Reference No:	2024/62/93255/W
Site Address:	17, Tanyard Road, Oakes, Huddersfield, HD3 4YW
Description:	Demolition of existing garage and erection of single storey side extension and alterations, and new balcony to rear with access to garden below
Recommending Officer:	Joshua Merriman

HOUSEHOLDER DELEGATED REPORT

Application Number	2024/93255
Location	17, Tanyard Road, Oakes, Huddersfield, HD3 4YW.
Proposal	Demolition of existing garage and erection of single storey side extension and alterations, and new balcony to rear with access to garden below.
Publicity end date	26/12/2024
Number of representations received	None
Kirklees Local Plan Allocation/Designation	No allocation in the Kirklees Local Plan.
Extension to Time (EoT)	No
Recommendation	Conditional Full Permission

Proposed Elevations 1:100 @ A1

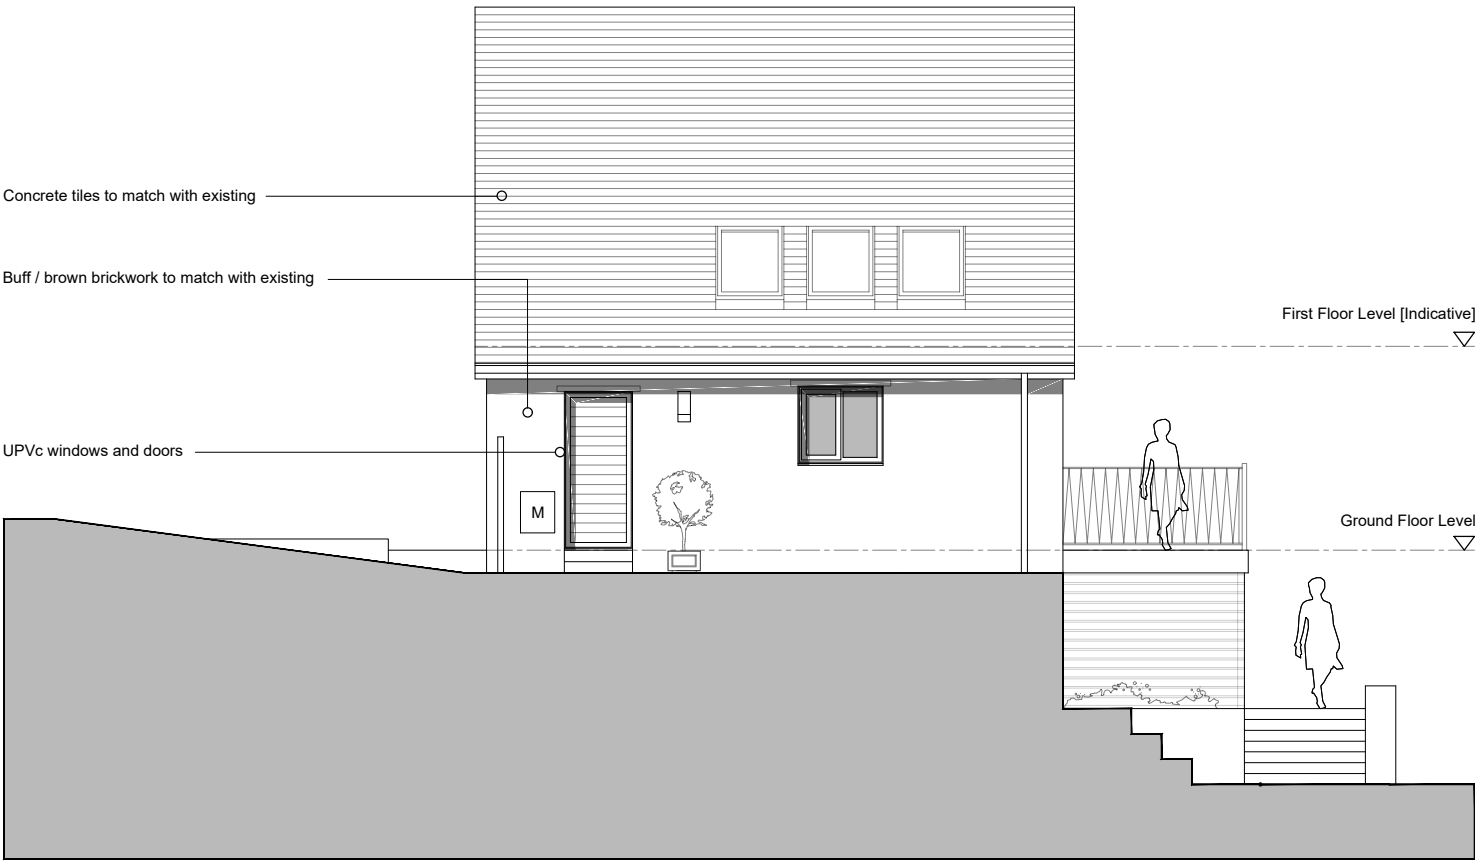
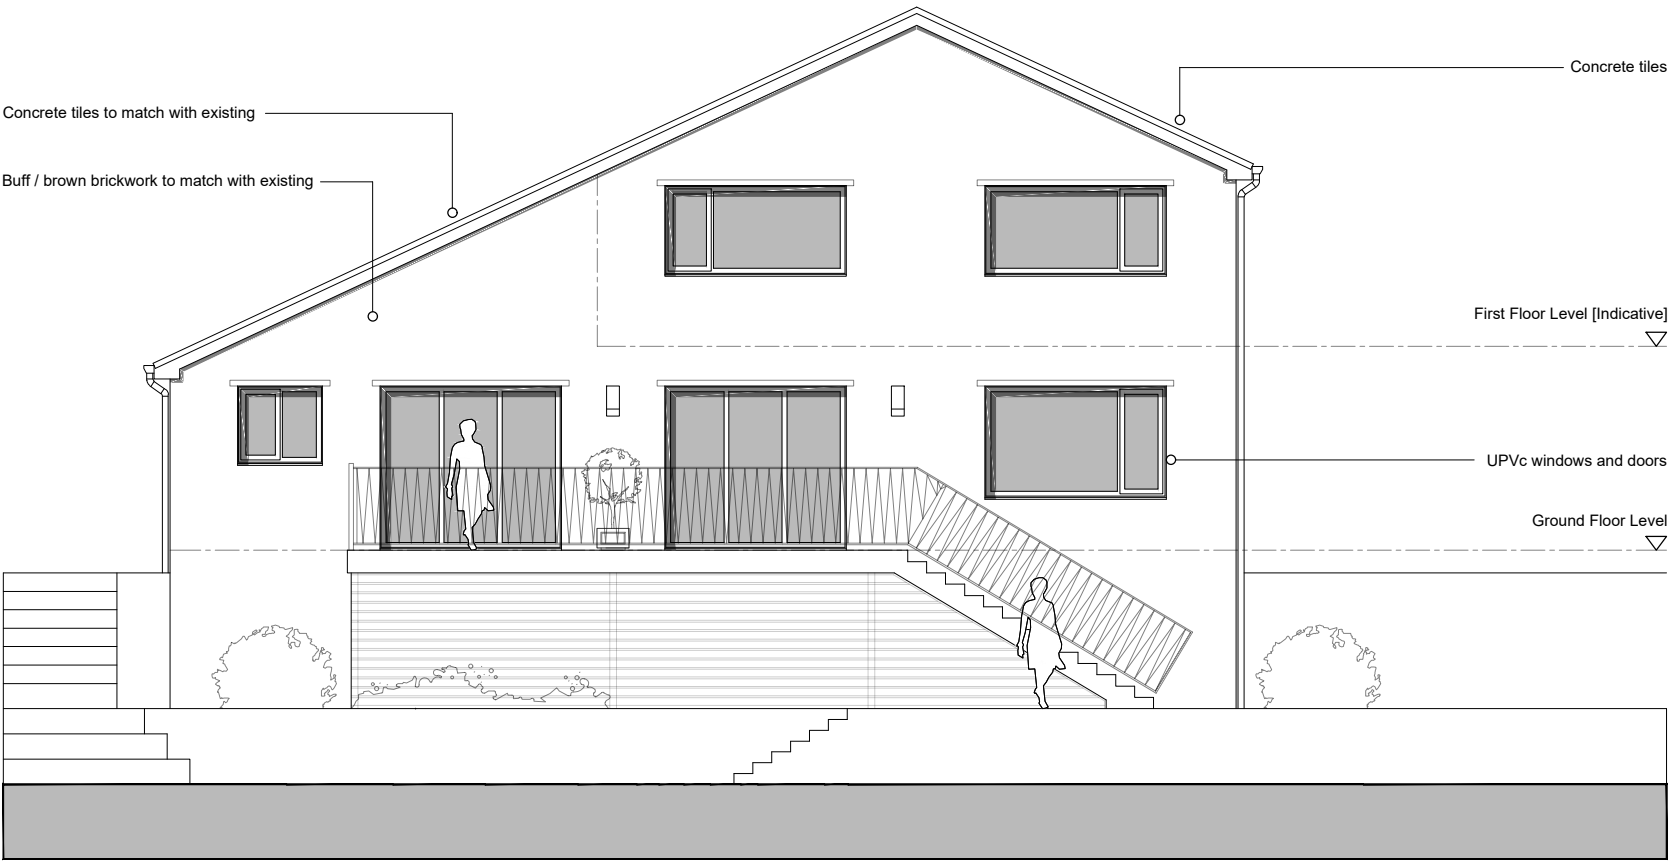
The proposed side extension will project 5.63m from the side elevation of the original dwelling, with a maximum height of 5.24m, eaves height of 2.51m, and a depth of 7.62m.

Positioning windows to minimise or avoid any potential overlook into neighbouring gardens		The proposed rear windows on the extension could facilitate minor overlooking into neighbouring gardens, however, they are not located significantly closer to the neighbouring garden than the existing rear windows, therefore, they are considered acceptable and to have no significant impact.
Single storey side extensions should:		
not extend more than two thirds of the width of the original house	The proposal does not extend more than two thirds of the width of the original house at only 5.63m, compared to the original house at 8.8m	
not exceed a height of 4 metres		The maximum height of the extension is 5.24m, however, it is still subservient to the original building and fits into the surrounding street scene, therefore, is considered acceptable.
be set back at least 500mm from the original building line to allow for a visual break		The extension would lie flush with the original dwelling, however, there are multiple side extensions and garages in the street scene that also lie flush with the host property, therefore, this proposal is considered to be acceptable as not departing too far from the street scene.

Positioned, and screened if required, so that they do not overlook neighbouring homes or gardens	Due to the distance and difference in elevation between the application property and neighbouring dwelling to the rear (8 Quarmby Croft), and taking account of the size / scale of the balcony, it is considered that the proposed balcony to the rear will not have a significant overlooking impact onto neighbouring occupiers.	
Sited away from locations that are sensitive to additional noise levels or disruption	The location is a residential area that is not sensitive to additional noise levels or disruption.

Facing materials and detailing	• KDP 9 of the SPD • Policy LP24 Design (d) (iii) of the KLP • Chapter 12 of the NPPF	For the proposed side extension, the walls are proposed to be constructed from natural stone, with the windows and doors all uPVC, all of which will match the existing building. As for the balcony, the agent confirms the use of steel and timber for its construction. These materials would be secured by condition.	✓
Roof style	• KDP 1 and 2 of the SPD	The roof is set to be concrete tiles to match the existing roof.	✓

3. Notwithstanding the plans submitted the external walls and roofing materials of the extension hereby approved shall in all respects match those used in the construction of the existing building. The walls of the balcony hereby approved shall in all respects match those used in the construction of the existing building or be constructed using steel frame and timber infill. The materials of construction approved by this condition shall be retained thereafter.
